Your Ref: OWPC24585
Our Ref: M/80/19/PL 16-09-2019
Please ask for:
Mrs A Gardner

Demolition of the existing structures & redevelopment to provide a new 66-bedroom care home (Use Class C2) arranged over two storeys together with associated access, car and cycle parking, structural landscaping and amenity space provision
Former Poultry Farm Land West of Yapton Road Middleton on Sea

Key:

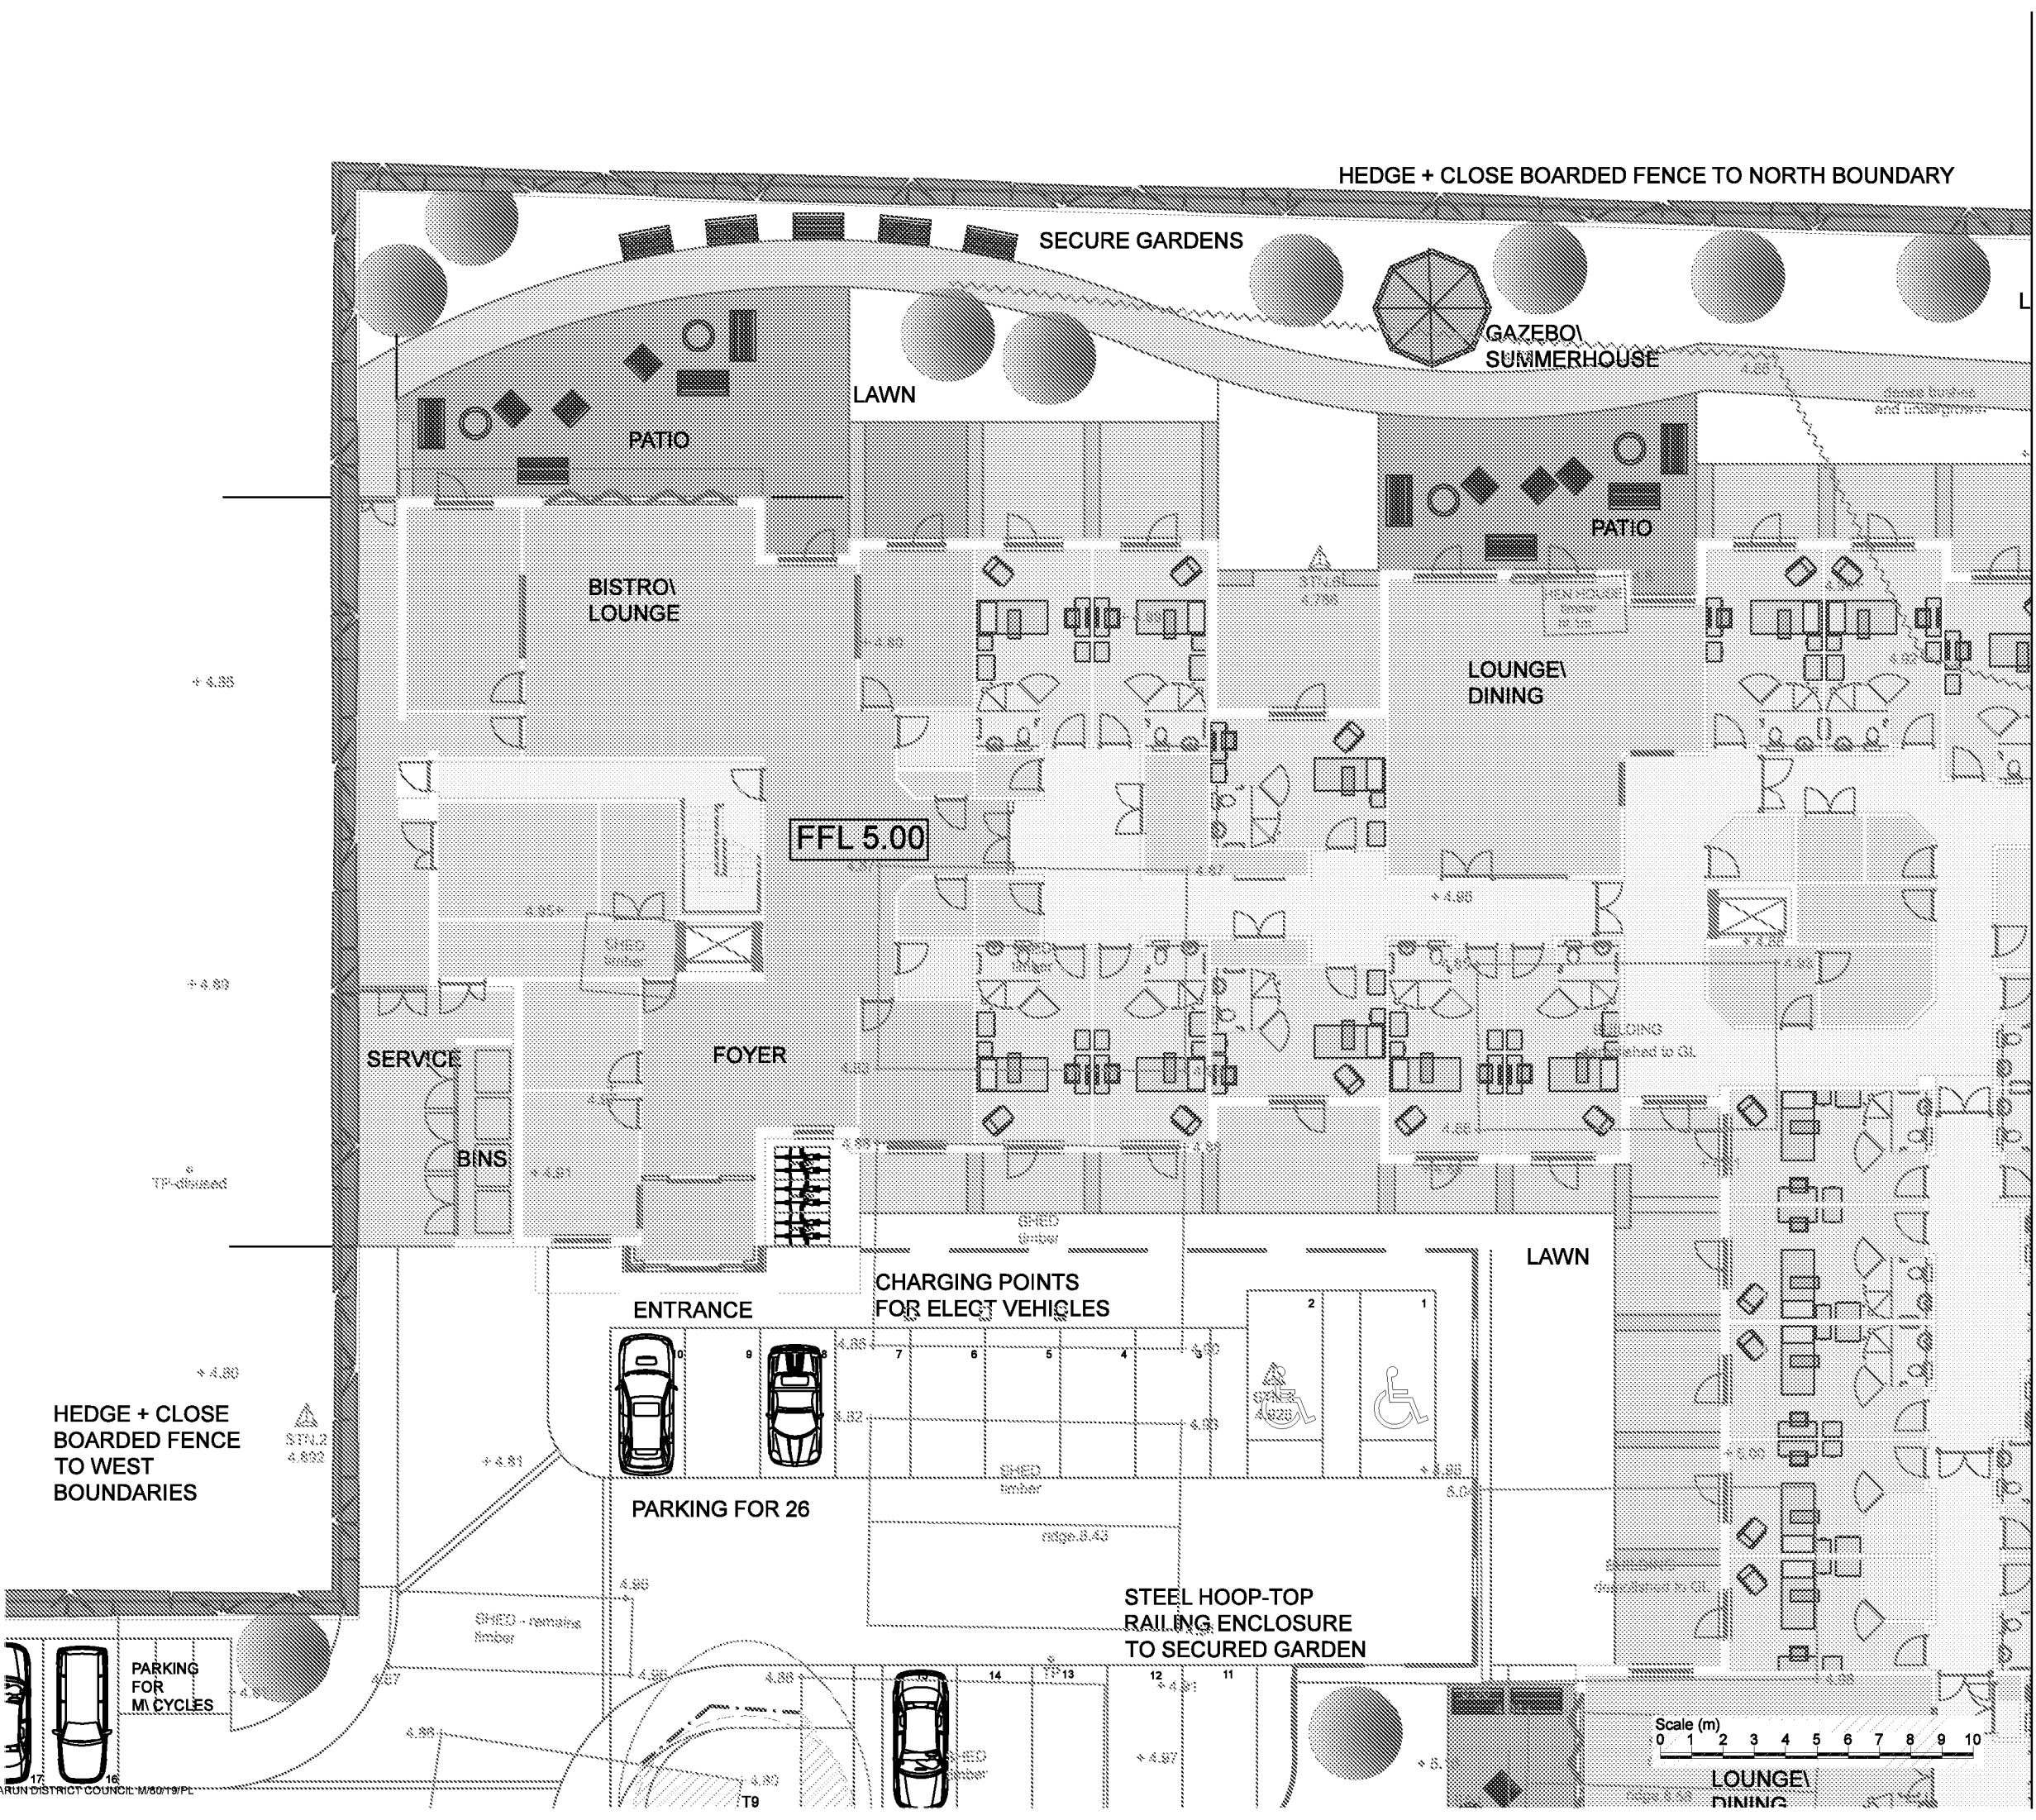
3, Ash tree, with a Tree Preservation Order fouling proposed access road onto site. The developer claim that they would protect the roots of this tree with a commercial system that has been used in similar situations, with, they claim success. However what they have not acknowledged is that a number of the tree's boughs and branches, hang very low over the width of the proposed entrance road, the lowest of which is only just over 2 metres above the proposed carriageway. These would have to be removed from the tree on day one to allow construction plant and vehicles to access the site and, in addition, pruning would need to be ongoing to ensure access to the site could be maintained. This work would involve substantial amount's of damage to the tree and on fears for it's long term health. In conclusion, we believe the proposed access to this site is not practical without severely damaging the tree with a TPO on it. We believe the developer should either find an alternative way onto the site or at the very least slew the access away from the Ash tree to minimise possible damage to roots, boughs and overhanging branches
